A1 Birtley to Coal House

Scheme Number: TR010031

Statement of Common Ground with Sunderland City Council

APFP Number:	
Planning Inspectorate Scheme Reference	TR010031
Application Document Reference	TR010031/7.5B
Author:	A1 Birtley to Coal House Project Team, Highways England

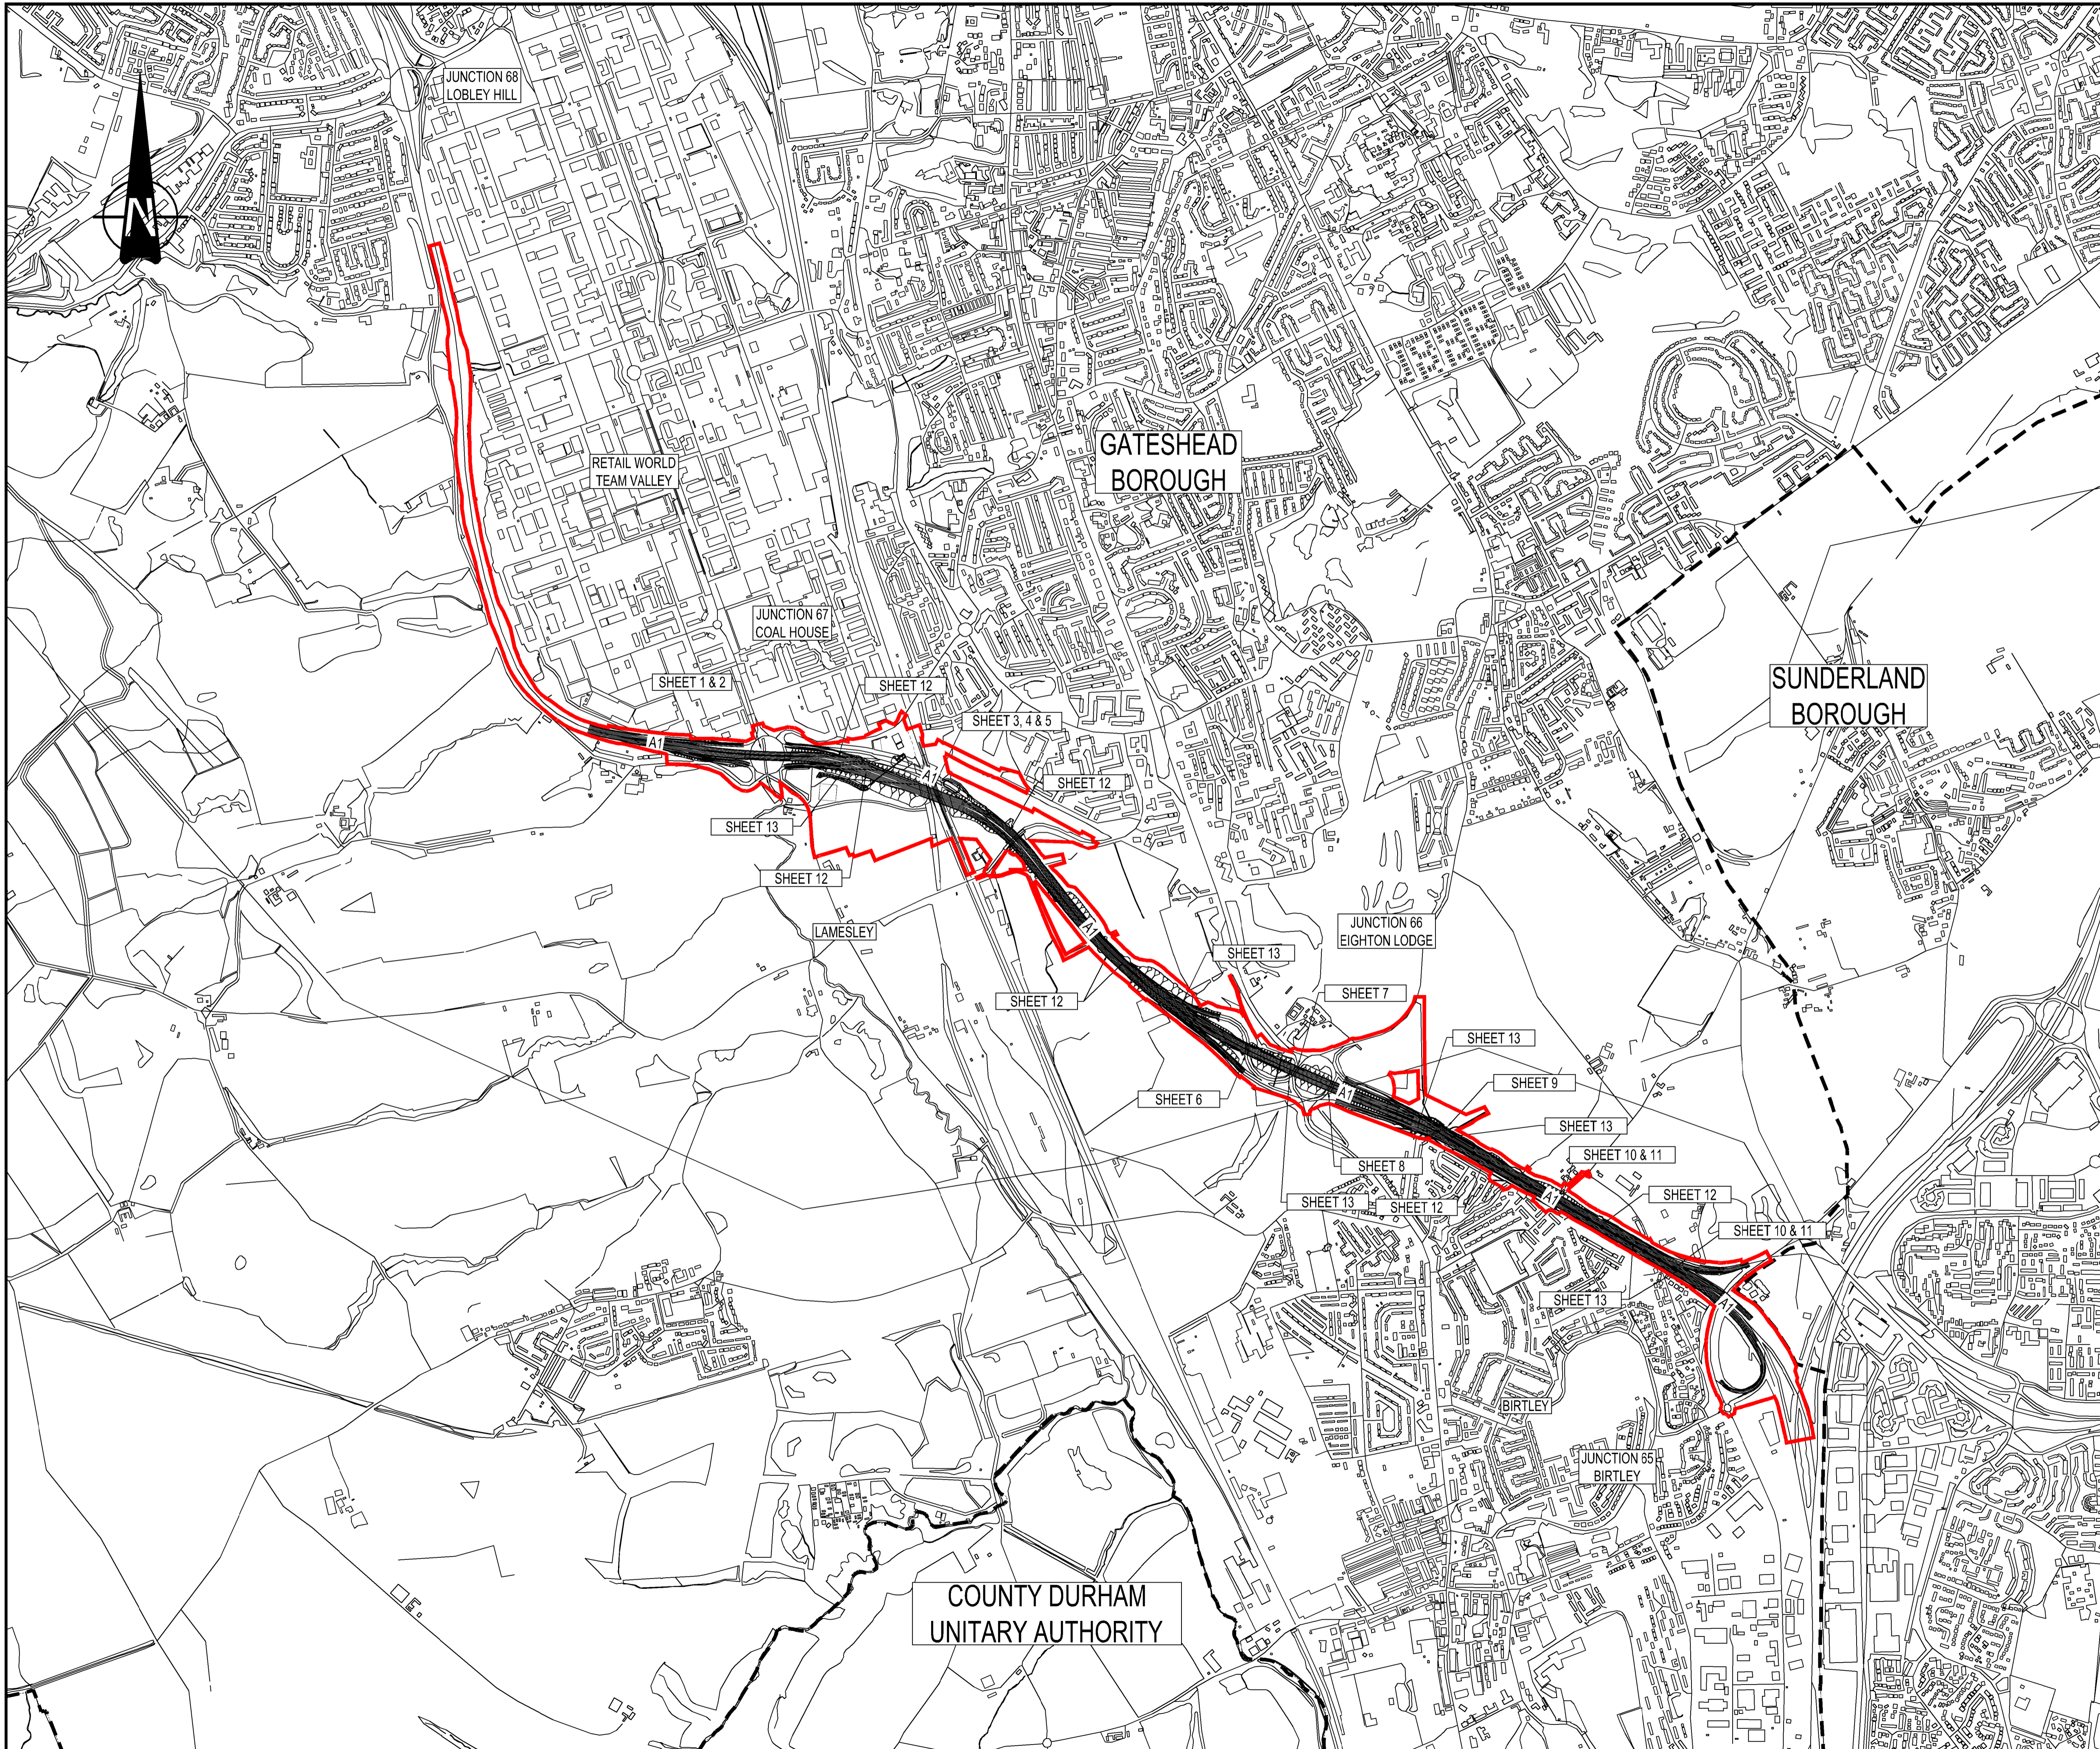
Section	Sub-section	Sunderland City Council Response	Highways England Position	Status
Structures Engineering Drawings and Sections [APP-011]	All	There are some text errors within the submission drawings relating to the naming of local authority areas of Gateshead, Sunderland and Durham which should be corrected. These include reference to 'Sunderland Borough', which should be corrected to 'Sunderland City Council.'	<p>The Proposed Scheme has been detailed in depth in numerous drawings and Sections provided as part of the submission, including the proposed design of:</p> <ul style="list-style-type: none"> • The Viaduct and Embankment Options • Ramp at North Dene Footbridge • Lighting of the underpass • Public Rights of Way diversions. <p>Plans have been updated to correct errors identified.</p>	Agreed
